Town & Country Planning Act 1990 (as amended)
Town & Country Planning (Development Management Procedure) (England) Order 2015
Application for Planning Permission for Works or Extension to a Dwelling

Development Proposed porch, first floor rear extension, tiled replacement to conservatory roof with alterations to fenestration and garden room

Location 50 Torton Hill Road Arundel

Proposed Site Plan 1:500

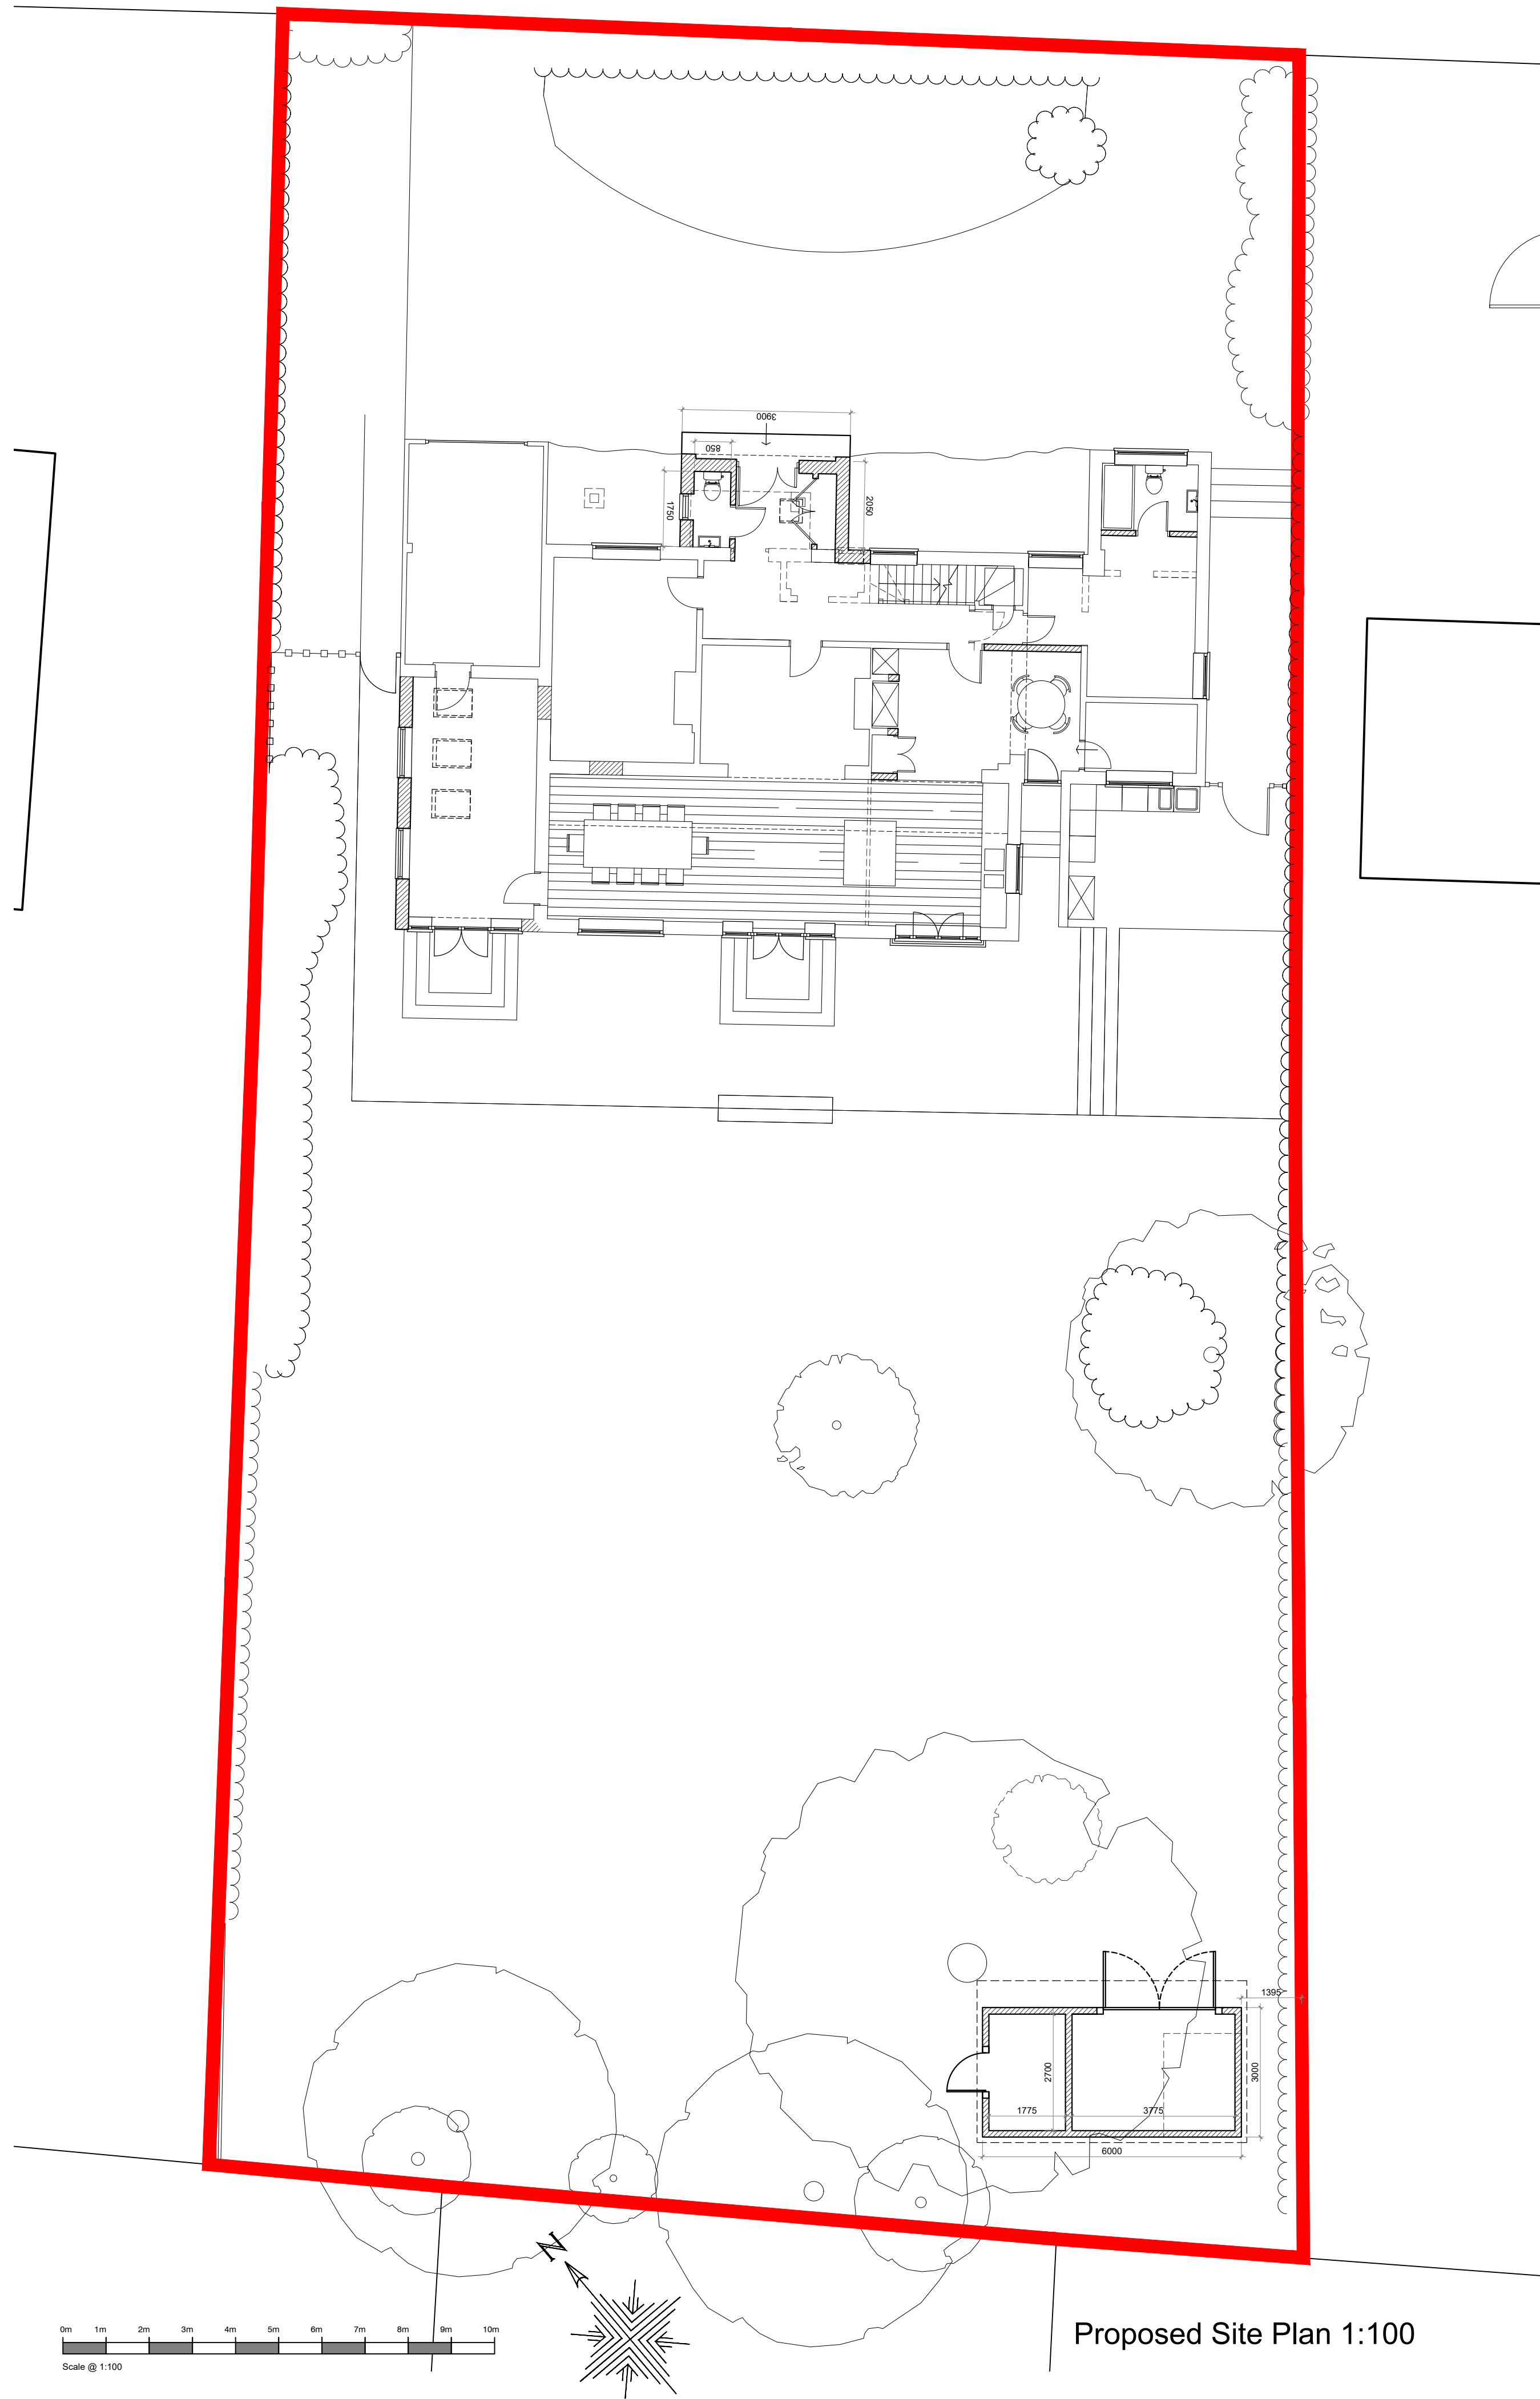
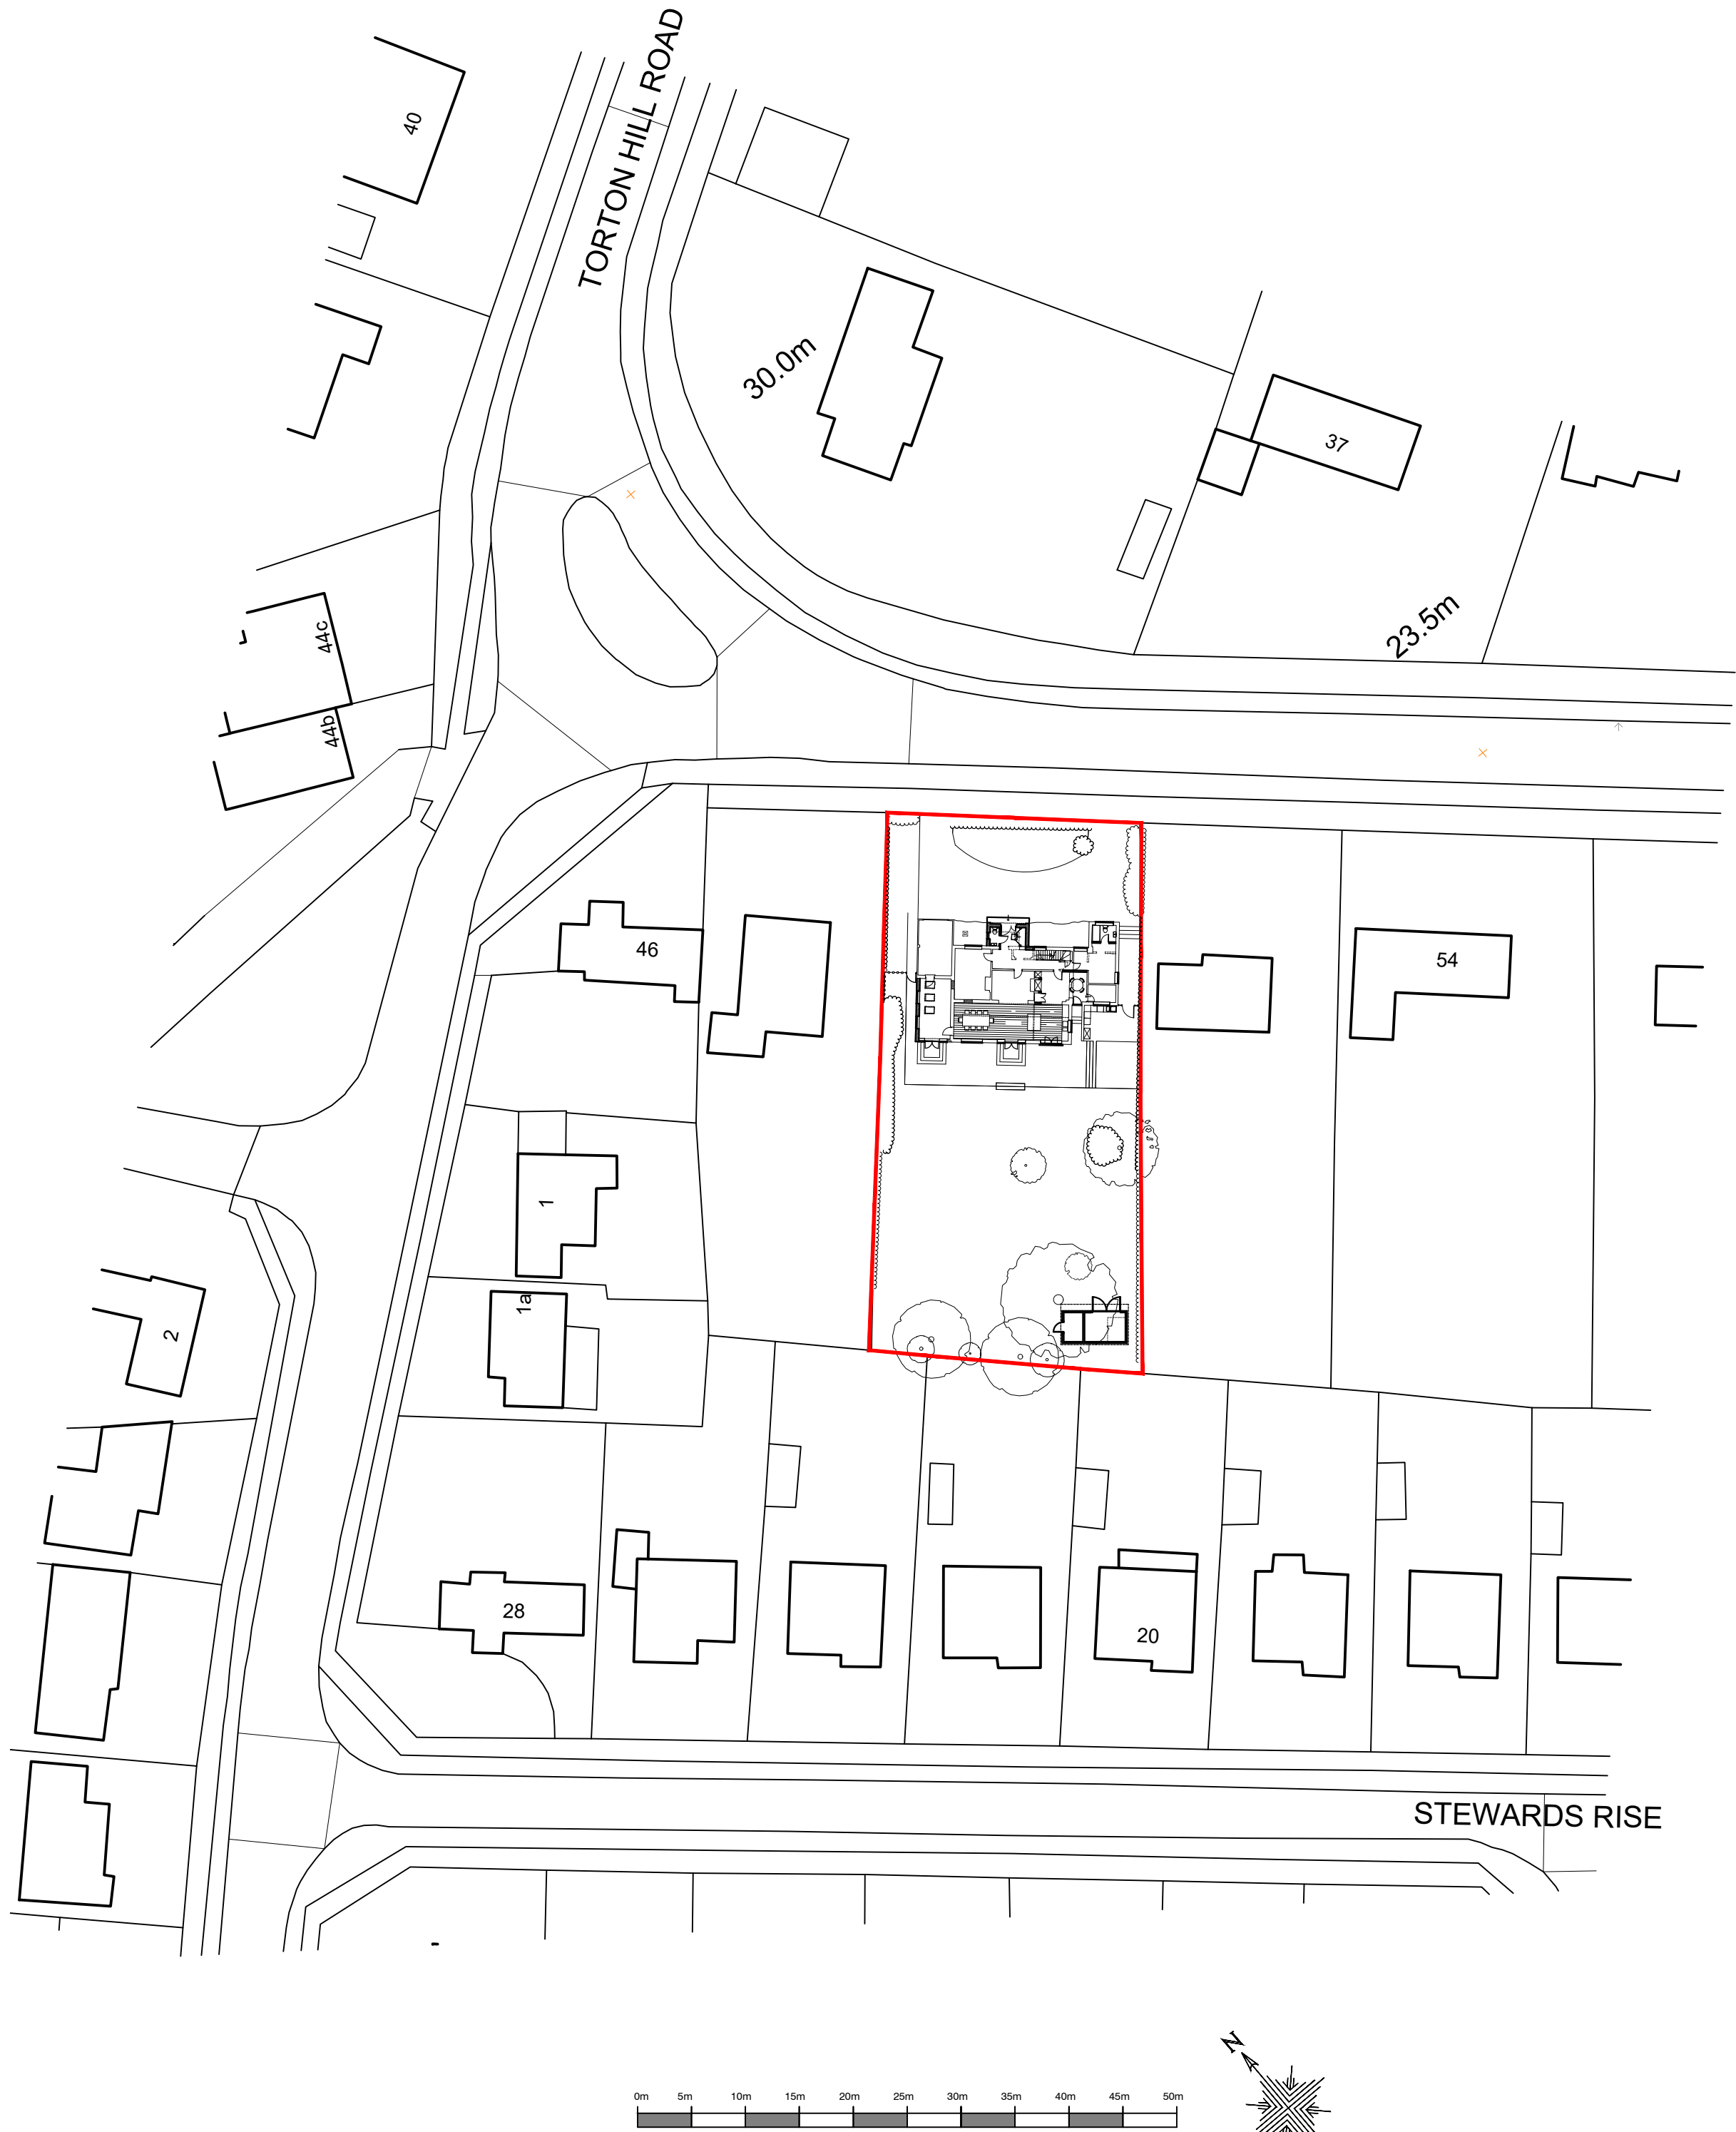
Block Plan

Please submit a block plan which includes dimensions from the proposed extension to all site boundaries.
